**Consultation Response from KC,
Trees**

2024/91002 Thongsbridge Tennis & Fitness Club, Miry Lane, Thongsbridge, Holmfirth, HD9 7RY

Formation of 2 outdoor covered padel tennis courts with 9m high polycarbonate canopy, one uncovered padel tennis court, relocation of modular building and existing outdoor tennis court and associated car parking improvements

Date Responded: 29/08/2024

Drawing Title: SITE_PLAN

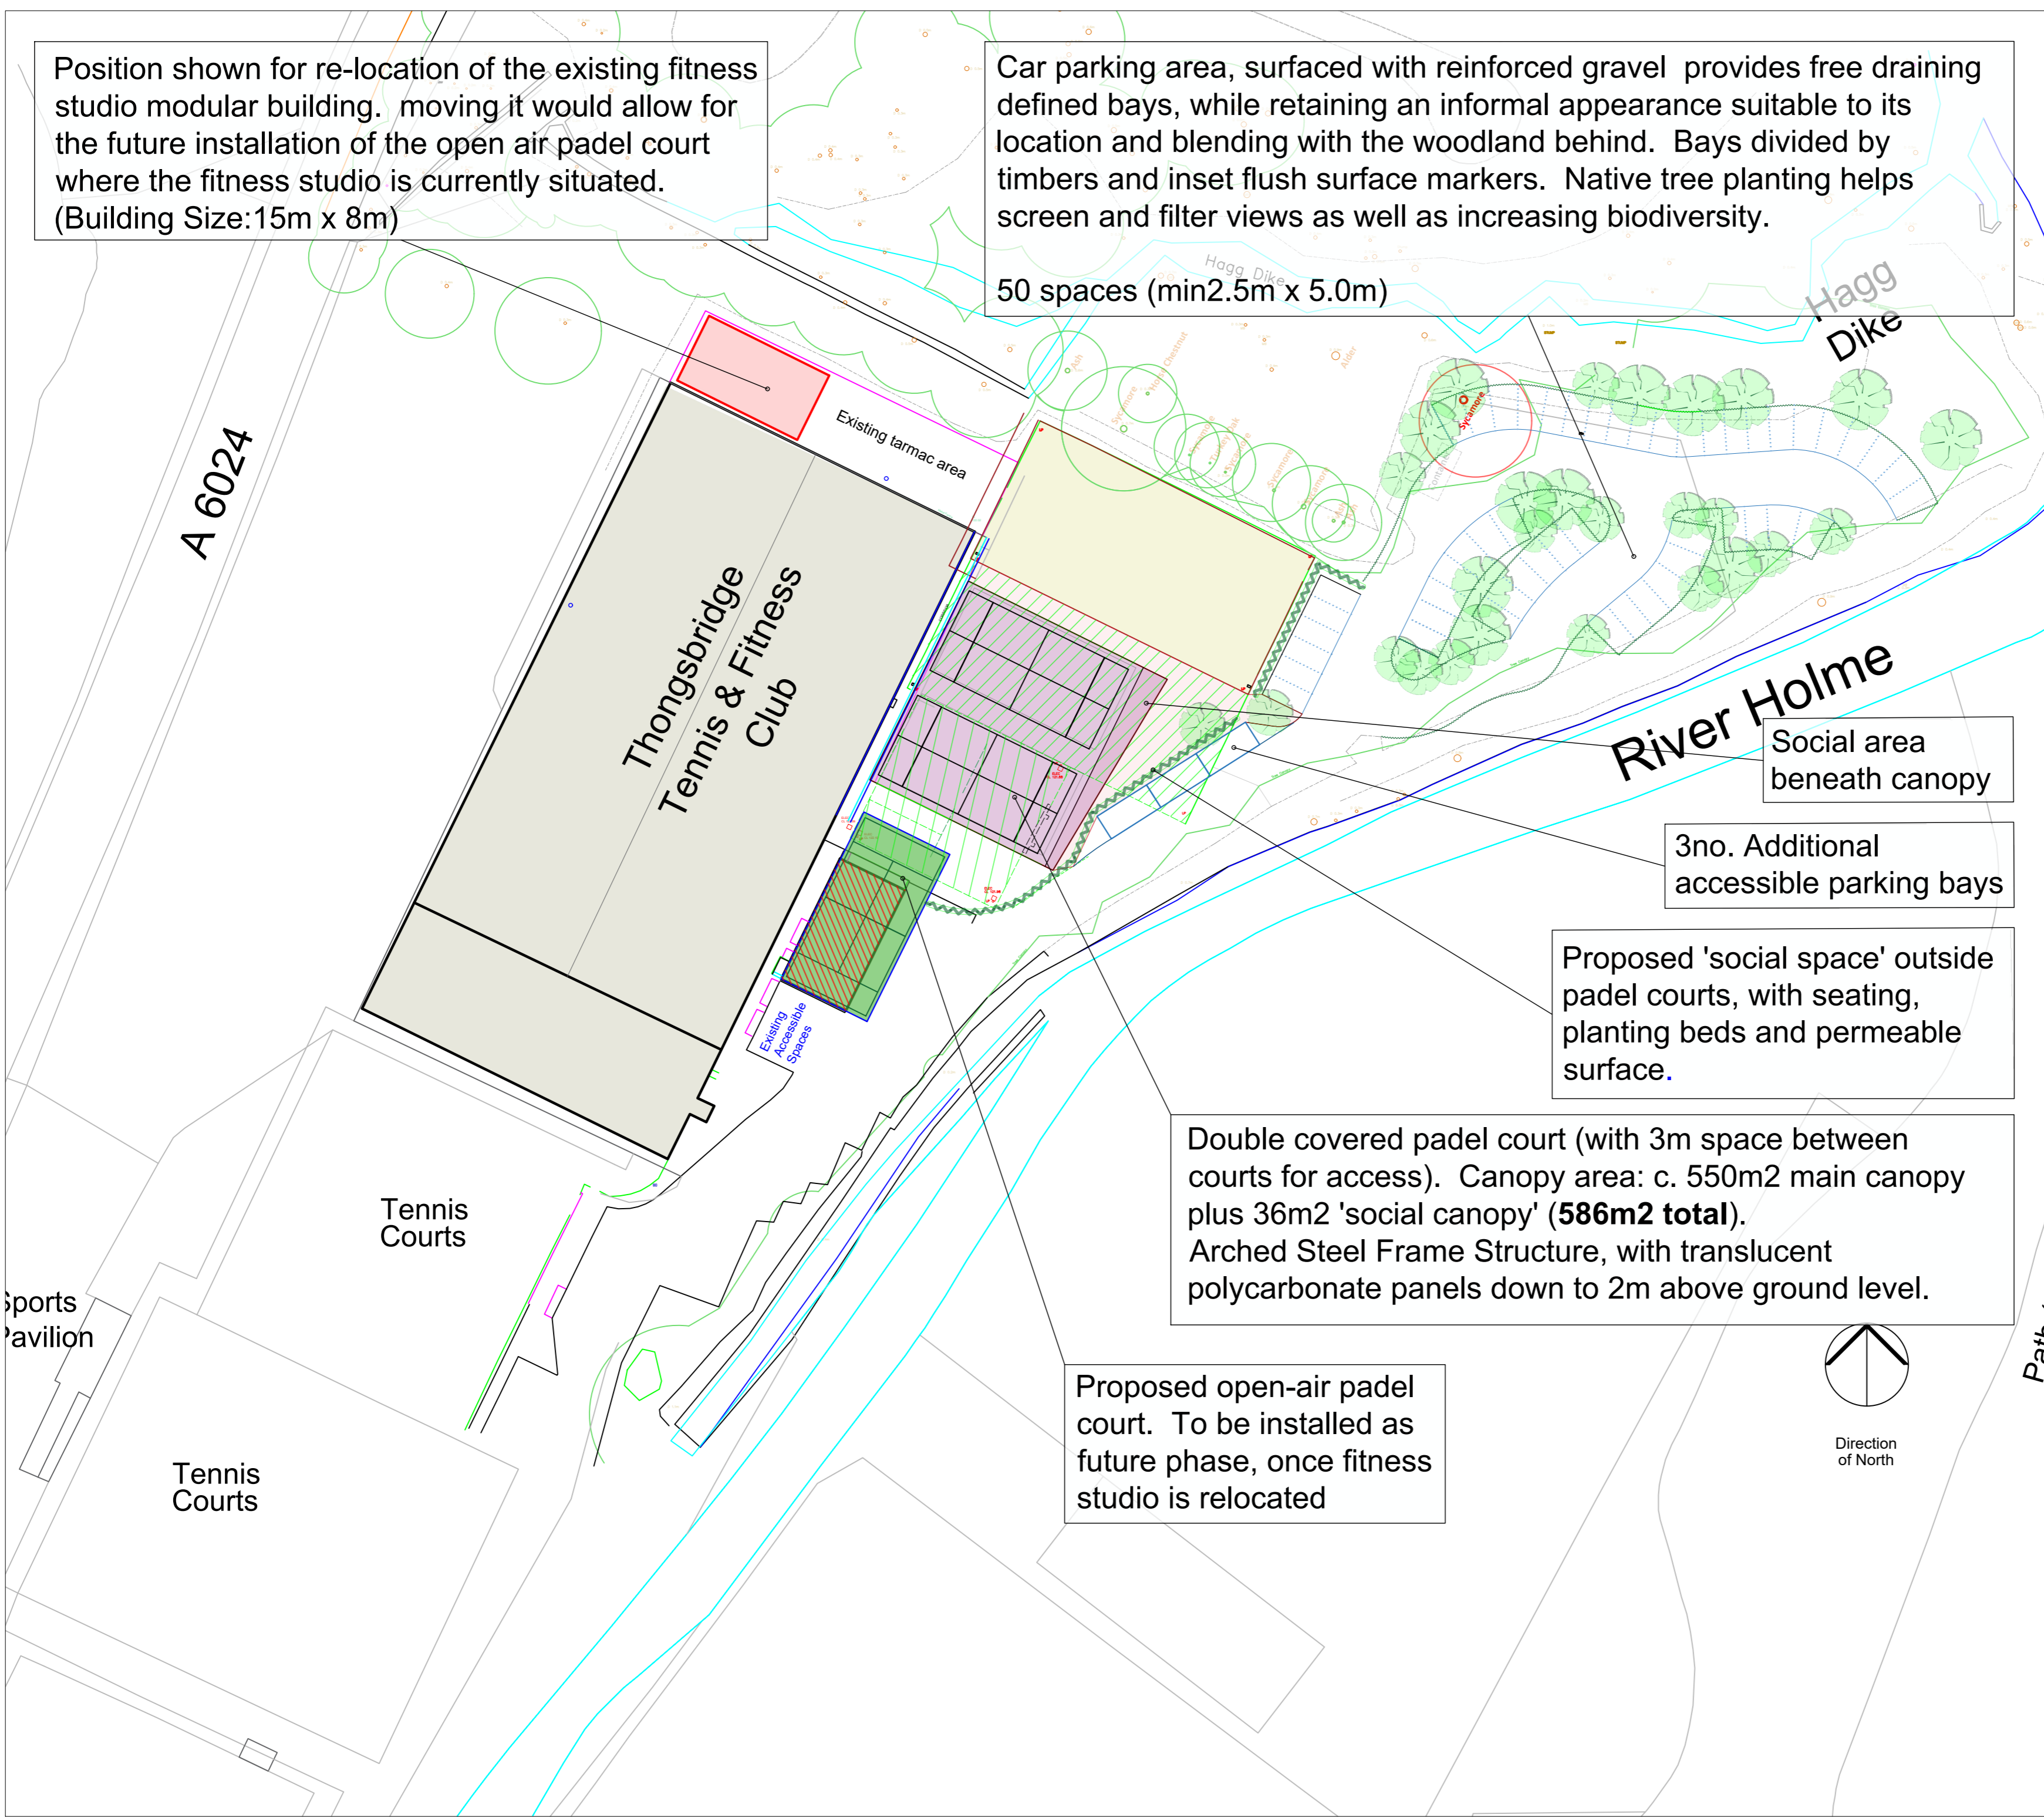
The current plans appear to show minimal impact on the surrounding trees apart from a large sycamore that is part of the ancient woodland to be removed in the North corner of the car park. This protected Sycamore could be retained through alternative design options.

Due to the proximity of all other works and the protected trees an Arboricultural Impact Assessment is required to make an informed judgement over the total impact on the trees. An Arboricultural Method Statement would also be required to show the measures that will be taken during the construction phase to protect the surrounding trees.
